From: Nicola Spencer
Sent: 04 December 2018 09:50
To: Karen Parsons
Subject: FW: M/101/18/PL - 134 Elmer Road - Middleton on Sea

M/101/18/PL - 134 Elmer Road - Middleton on Sea

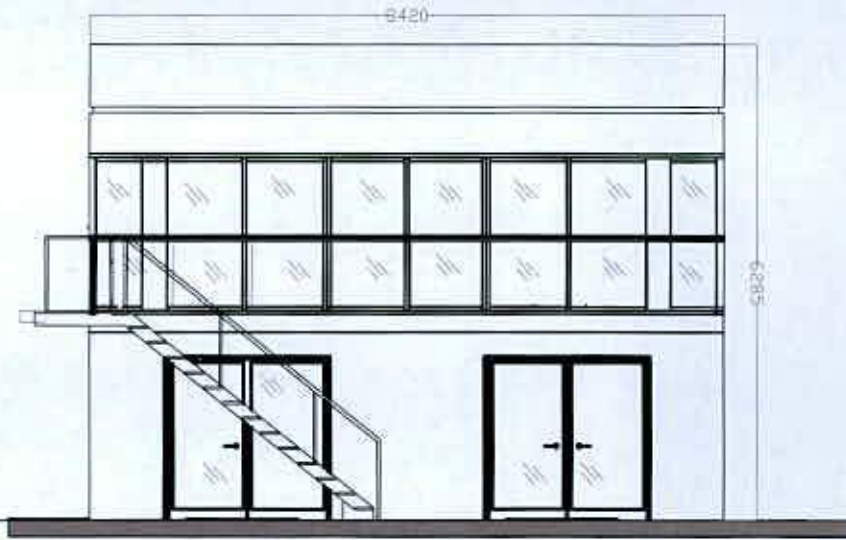
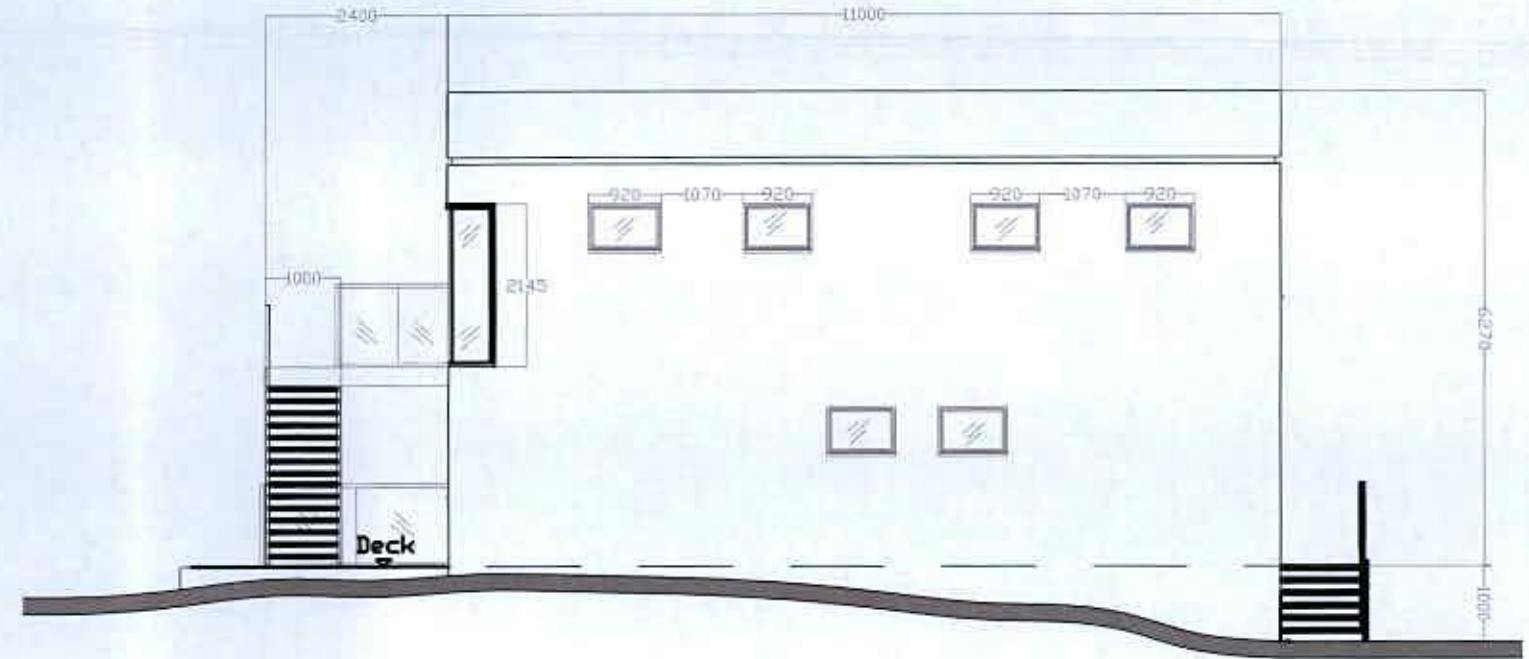
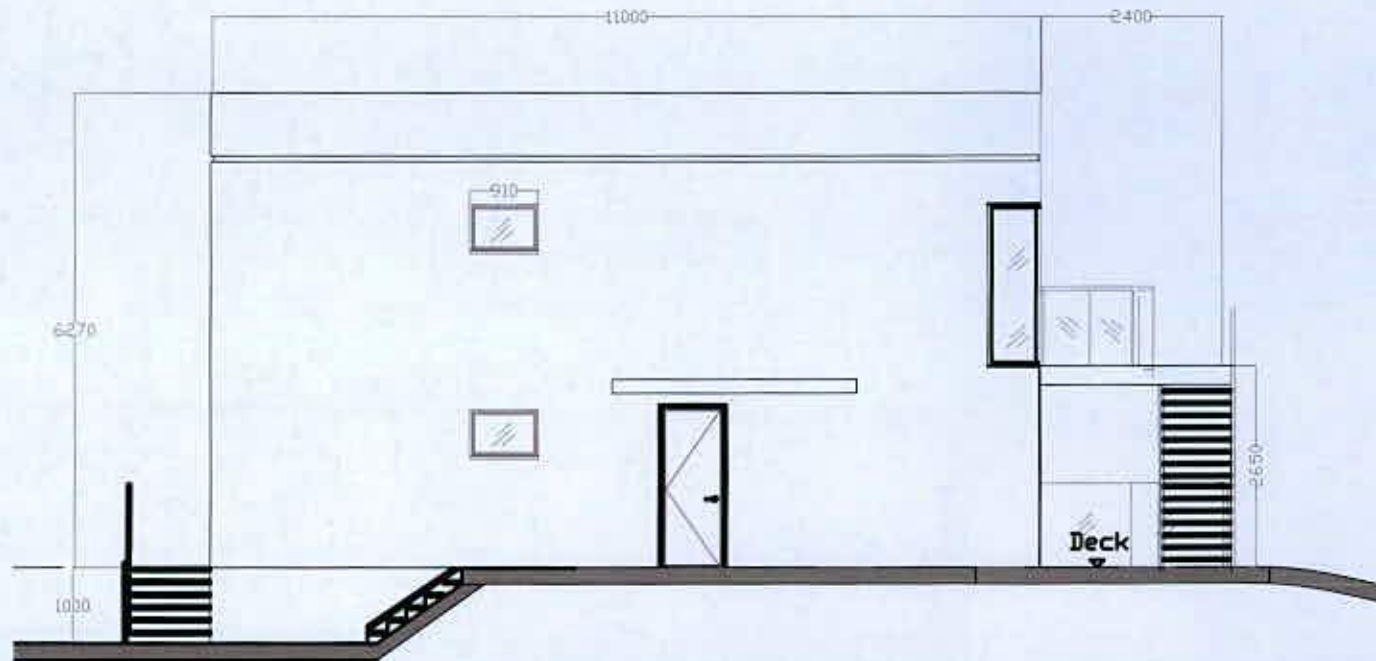
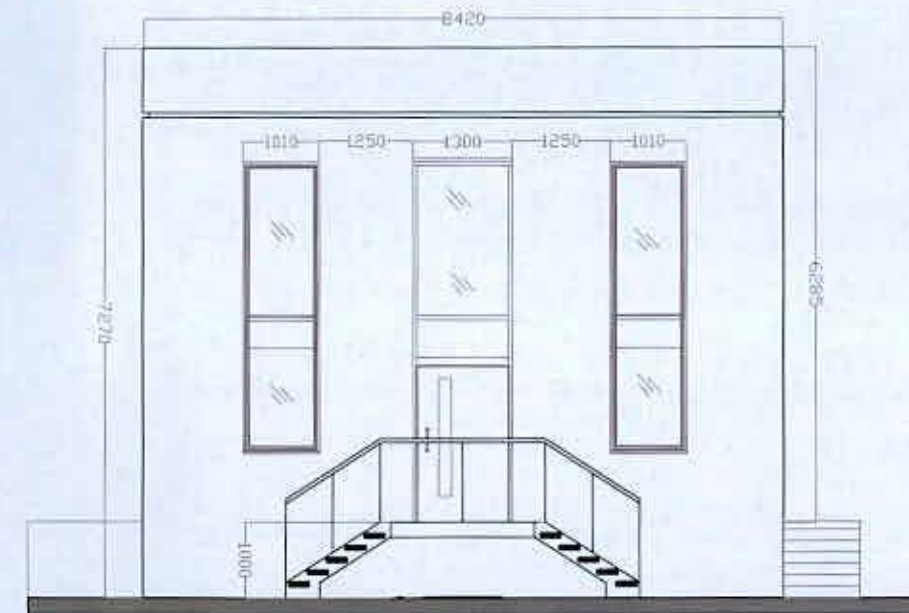
- 1) Whether or not you are applying for a residential use or a commercial holiday home use.
- 2) Opaque side screens to the proposed balcony as requested in the pre-application advice.
